## **FIRE RISK MANAGEMENT, INC.**

# **Memo Report**

**Subject: Updated Fire Hazards Assessment of the Liquid Riot Bottling Company at  
250 Commercial St., Portland, ME.**

A1.01

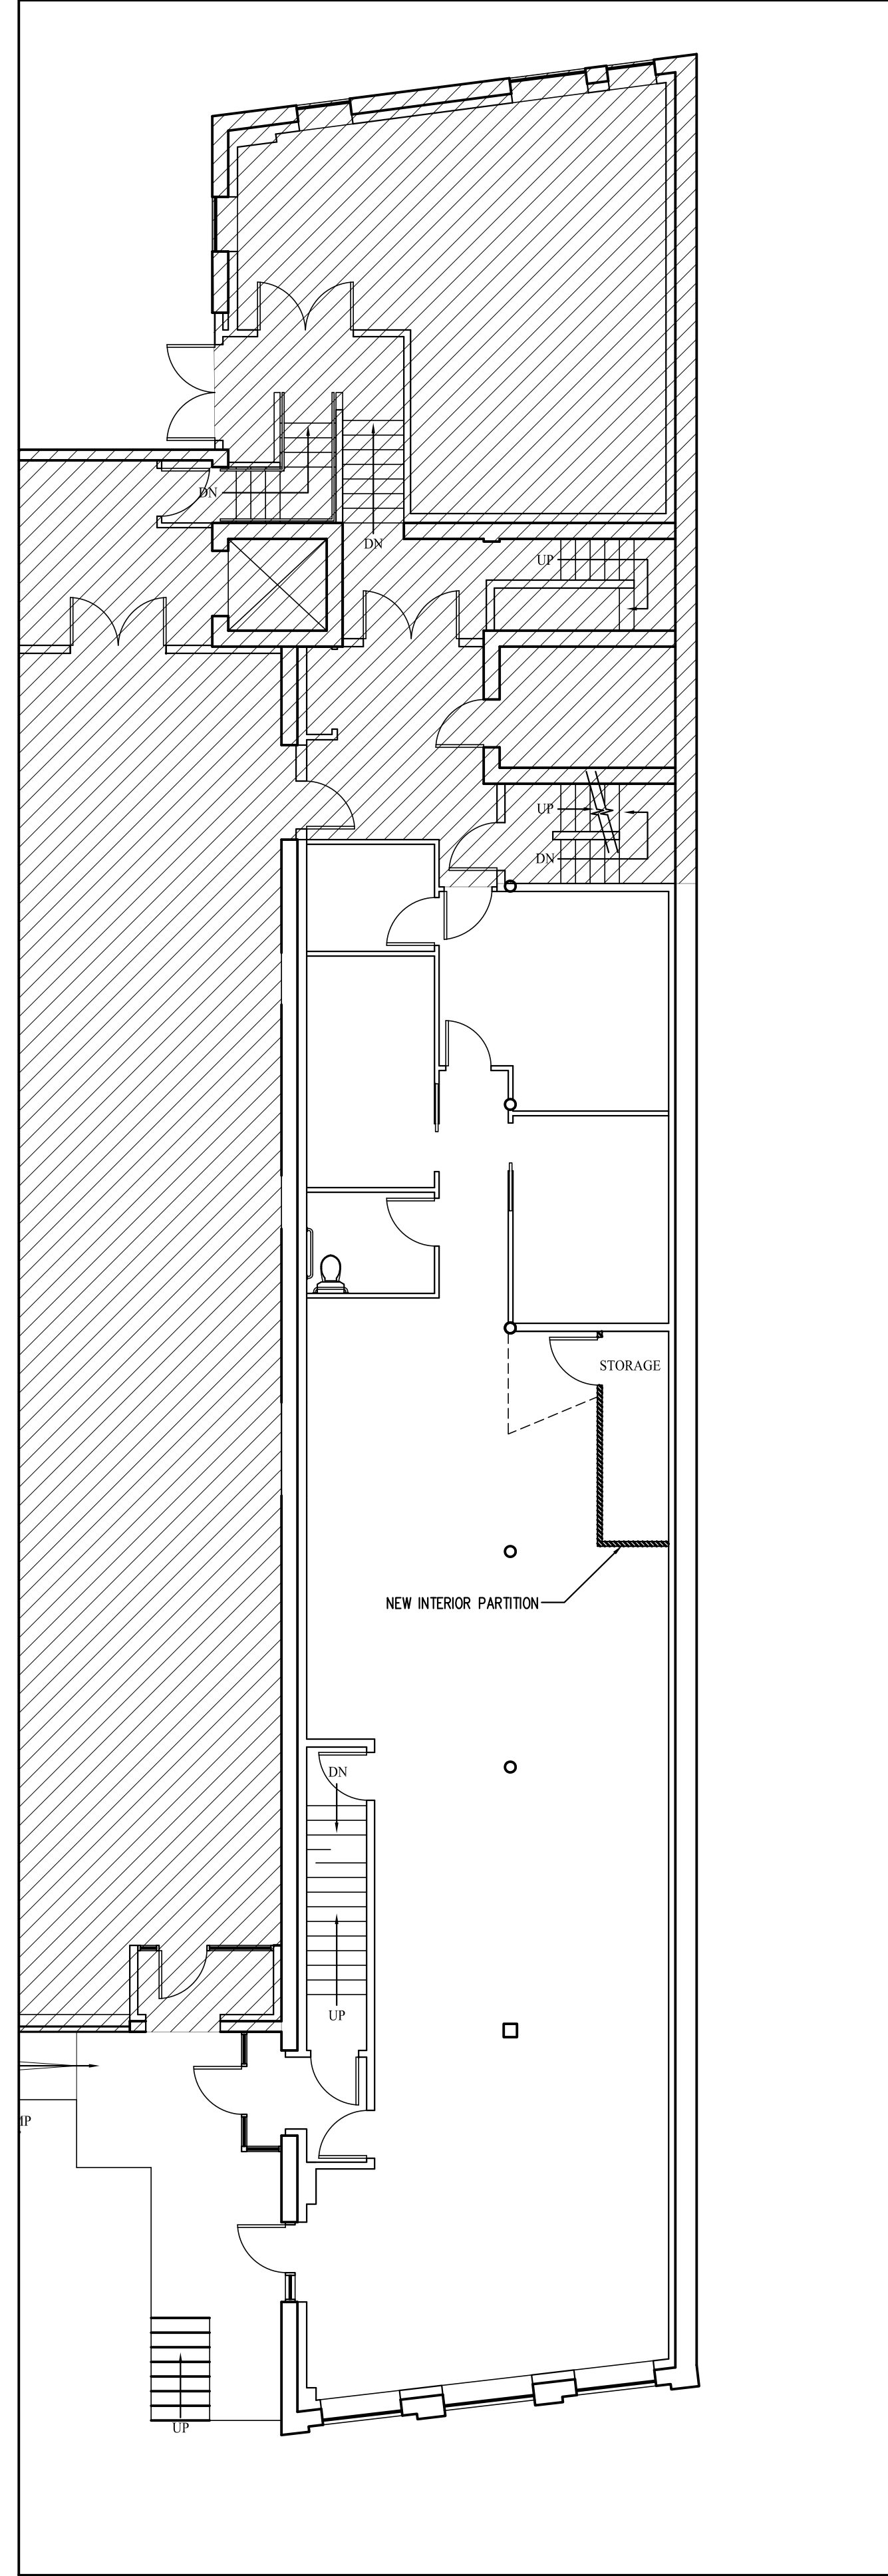
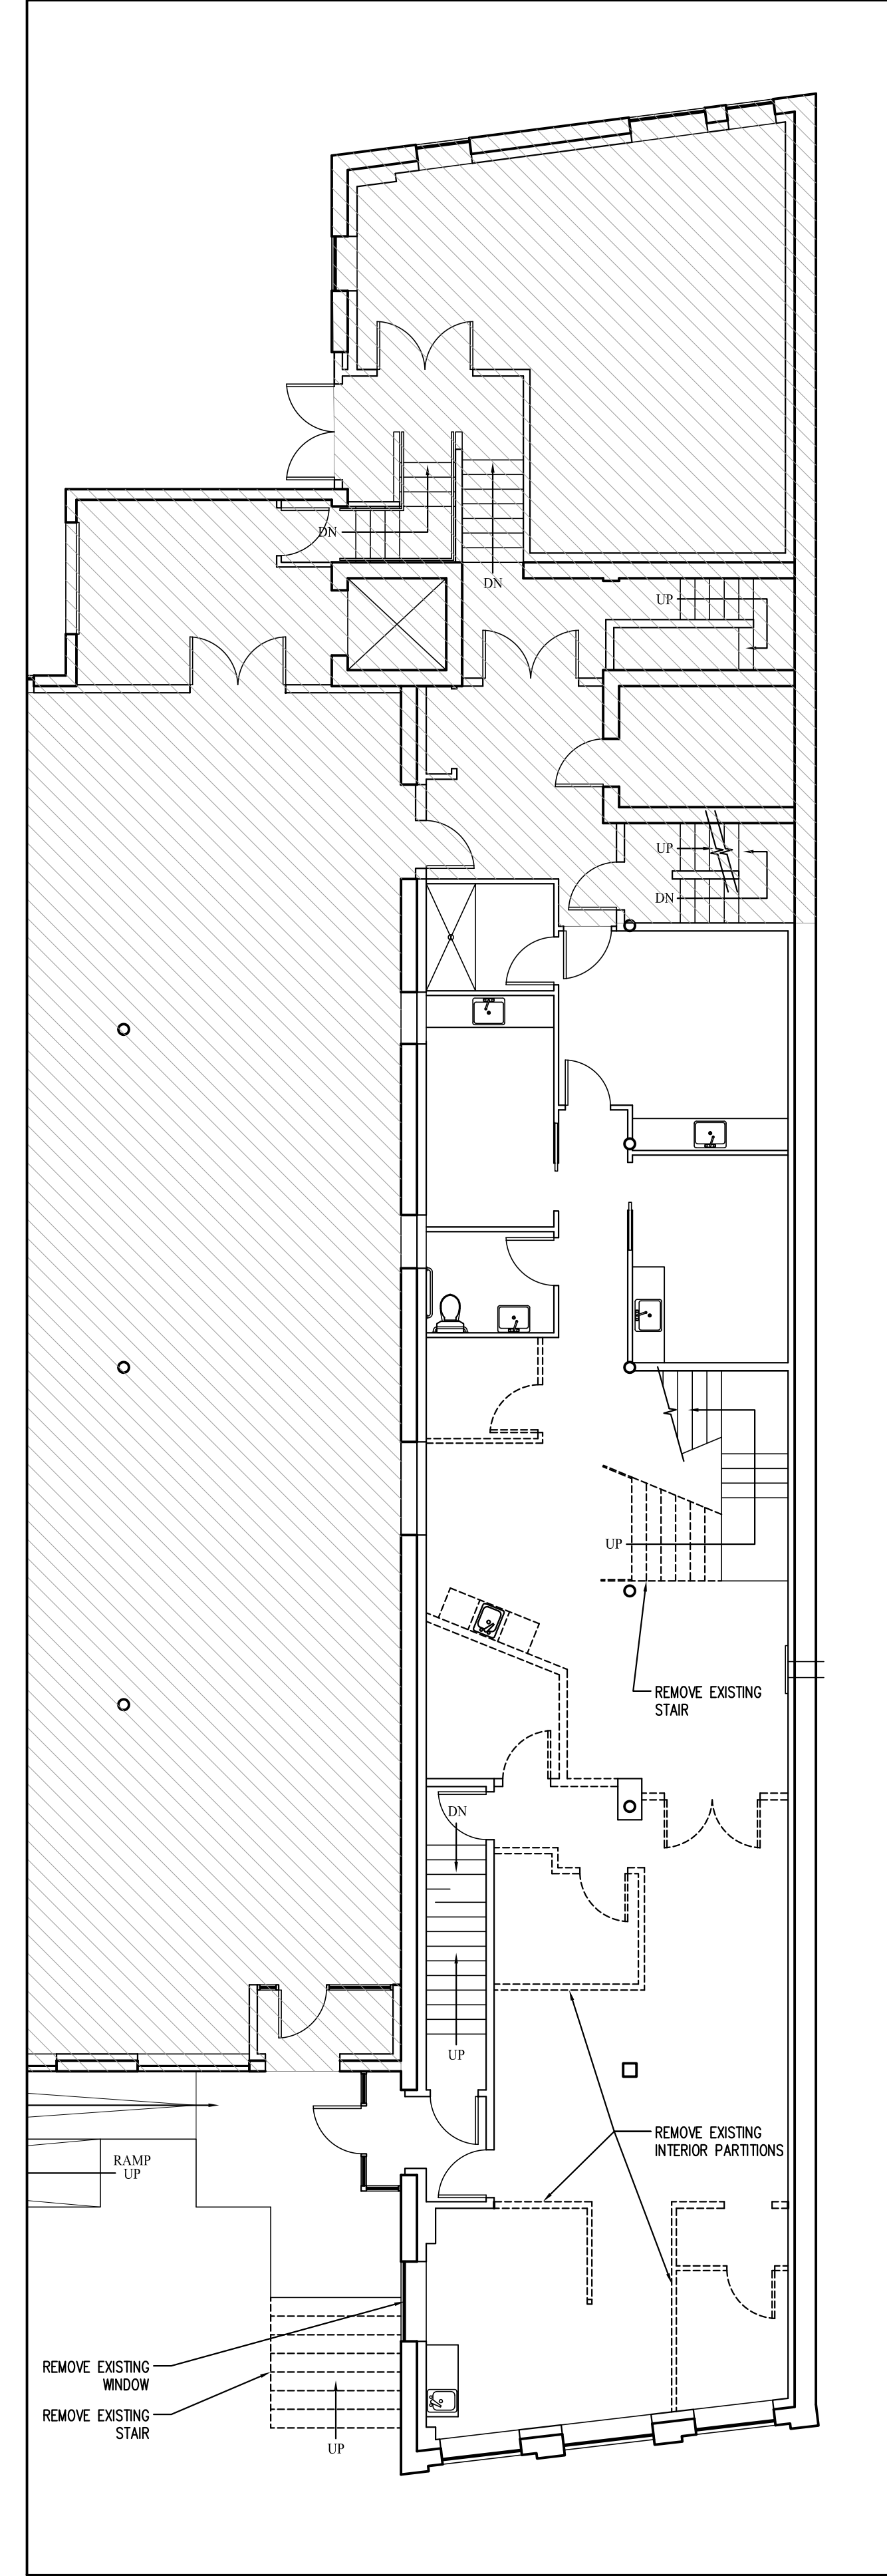
A review has been conducted of the updated layout/construction for Liquid Riot Bottling Company facility, which includes a small distilling operation, along with the addition of a new storage area for distilled spirits that are being aged in wood barrels. The new barrel storage space is to be located on the 2<sup>nd</sup> floor level of the facility, which is located at 250 Commercial Street in Portland, ME. The primary purpose of this updated review is to evaluate the current (as-built) configuration of the brew pub facility and evaluate any potential code compliance issues associated with the addition of the new barrel storage area on the 2<sup>nd</sup> floor level.

The building appears to generally meet the requirements of a Type IIB construction, as defined by the IBC. The exterior walls are all listed as being of masonry construction; nominally 8 inches thick. The floor/ceiling assembly that separates the 1<sup>st</sup> and 2<sup>nd</sup> floors consists of a concrete slab that is supported by exposed steel beams and columns. The space that is to be dedicated for the distilling operations is located along a portion of the northwest exterior wall; that adjacent to Commercial St. The barrel storage room is to be located at the northeast corner of the 2<sup>nd</sup> floor area.

1. Ensure the new barrel storage area is separated from the remainder of the facility by barriers that have a fire resistance rating of at least one hour.
2. Ensure that anytime flammable liquids are being transferred between containers within the distilling area that a portable fire extinguisher is readily accessible within this area.
3. Transfer of barrels from the distilling area to the 2<sup>nd</sup> floor storage room should be limited to periods when the facility is not open for public occupancy.
